**From:** Amanda Scholes on behalf of Planning.Responses  
**Sent:** 26 January 2021 09:55  
**To:** Planning Scanning  
**Subject:** FW: Tyrone House Norton Lane Norton PO20 3NH - AL/2/21/DOC  
**Attachments:** The LED Store Project 2784.pdf

**Planning Application Reference: AL/2/21/DOC**

**Proposal: Approval of details reserved by condition imposed under ref AL/51/20/PL relating to Condition Nos 3 - materials & finishes, 5 - Energy Statement, 7 - car parking and 14 - external lighting**

**Address: Tyrone House Norton Lane Norton PO20 3NH**

FIGURE 2 - PROPOSED EXTERNAL LIGHTING

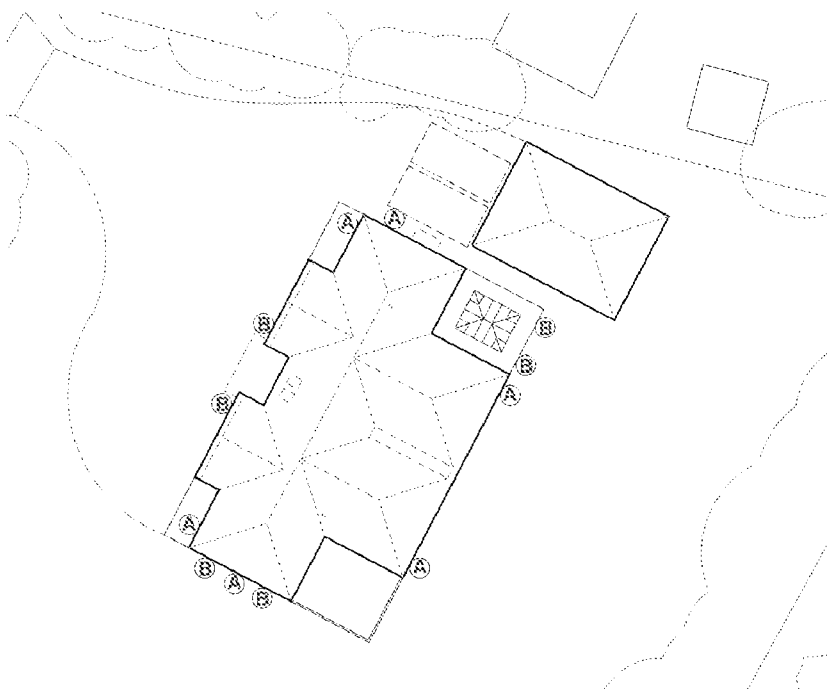
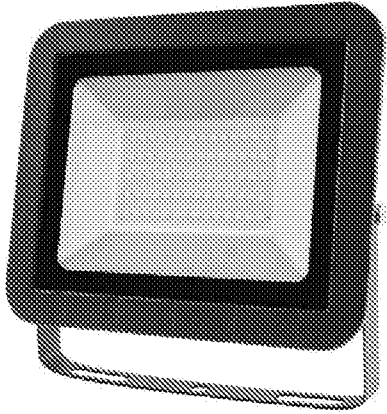
There is insufficient information to determine whether the proposed external lighting may potentially cause a light nuisance to neighbours. I note the proposed location of spot lights 'A', however a lux diagram showing the spot light orientation and extent of light spill is required to assess for potential light nuisance. I therefore recommend that the applicant be required to submit a lux diagram illustrating the orientation and extent of light spill from the proposed spot lights.

I therefore do not recommend discharge of condition 14 (external lighting) based on the submitted information.

We have revisited the previously suggested spotlight fitting (referenced A in Figure 2) and would like the attached fitting to be considered instead. Lux diagrams for this fitting included.
